WEST SUSSEX COUNTY COUNCIL CONSULTATION

TO:	Arun District Council FAO: Andrew Wood
FROM:	WSSC - Highways Authority
DATE:	4 May 2021
LOCATION:	125 Bayford Road Littlehampton BN17 5HW
SUBJECT:	LU/131/21/DOC Approval of details reserved by condition imposed under ref LU/13/21/PL relating to Condition Nos 3 - covered & secure cycle parking and 4 - electric vehicle charging space.
DATE OF SITE VISIT:	n/a
RECOMMENDATION:	Advice
S106 CONTRIBUTION TOTAL:	n/a

This application seeks discharge of conditions 3 and 4 of approved LU/13/21/PL.

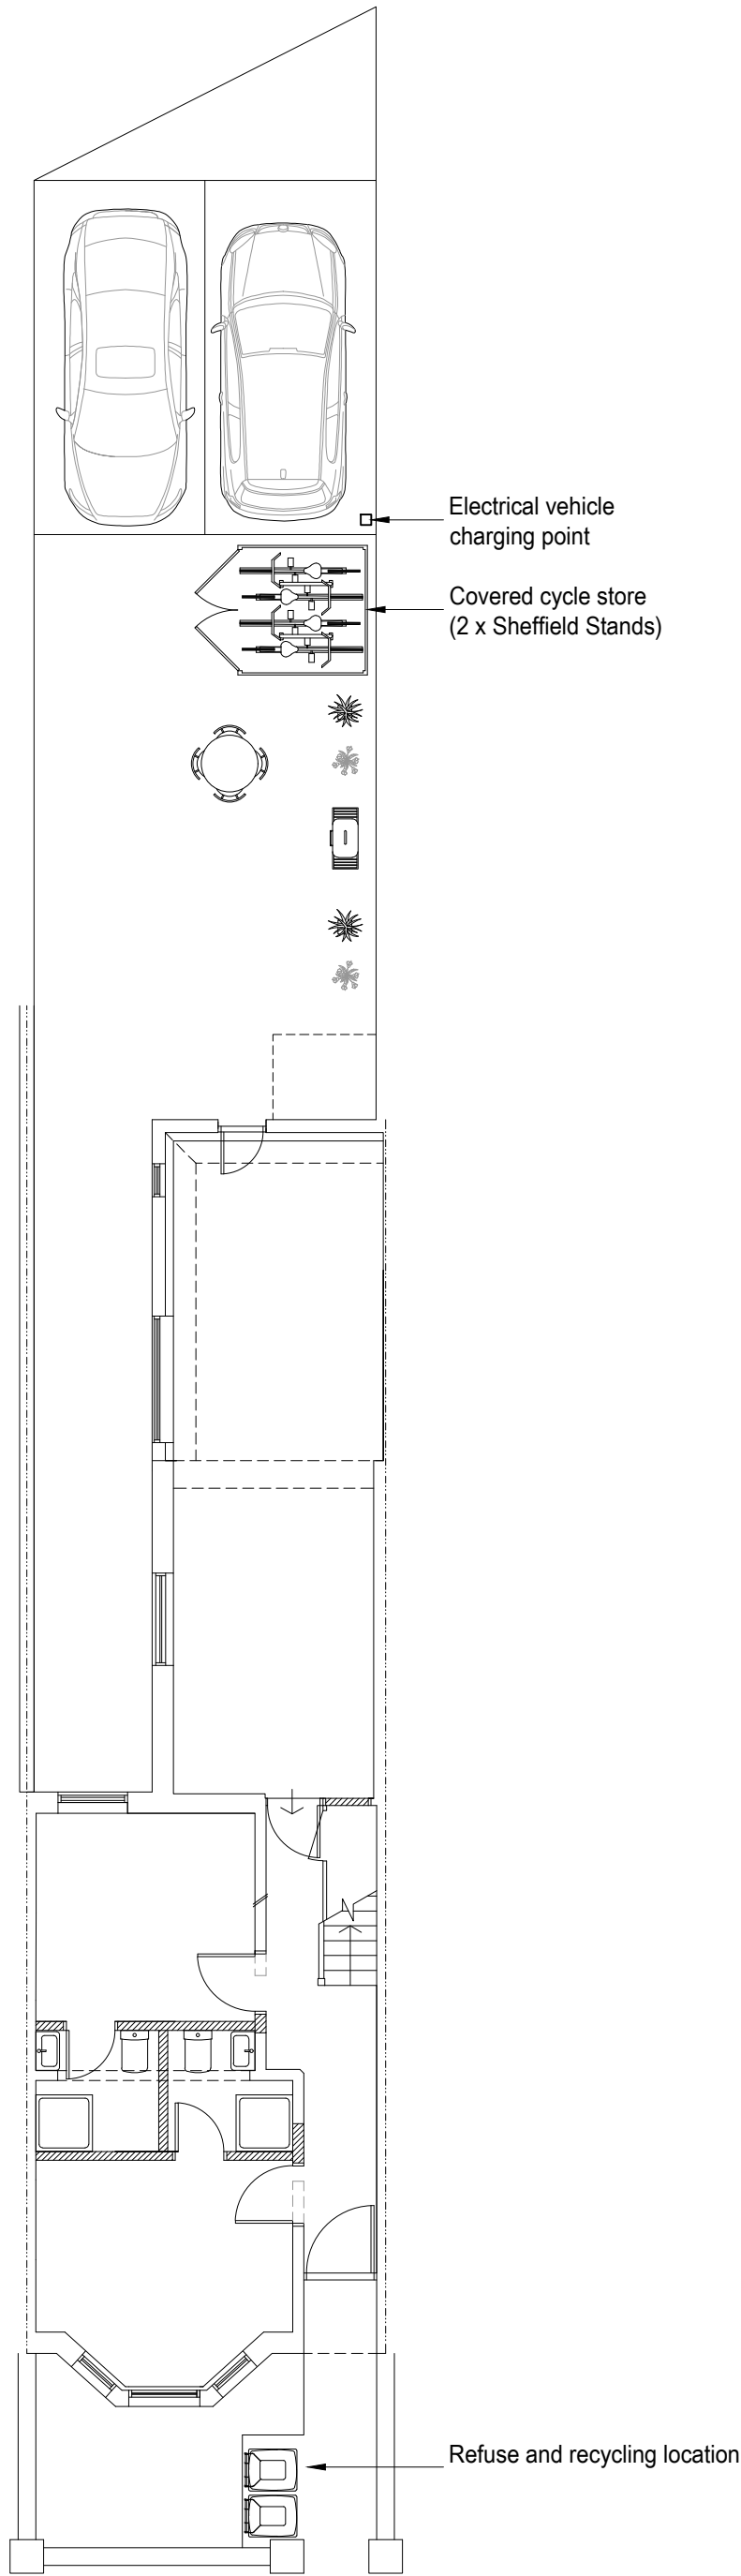
The provided plans demonstrate secure and covered cycle storage for 4 bicycles. The LHA note that is provision has been reduced from the originally proposed provision of 8 cycle spaces. However, the LHA is satisfied with the proposed provision, encouraging sustainable methods of transport for residents of the HMO.

The provided plan demonstrates one EV parking space for the proposed HMO use. This is not in accordance with the Arun District Council Parking Standards SPD (January 2020) which expects 100% of parking spaces to be provided with EV charging facilities. The LPA is advised to consider whether the proposed provision is sufficient.

The LHA is satisfied that both conditions 3 and 4 can be discharged, however advise the LPA to consider whether the EV provision is sufficient given the guidance within the Arun District Council Parking Standards SPD.
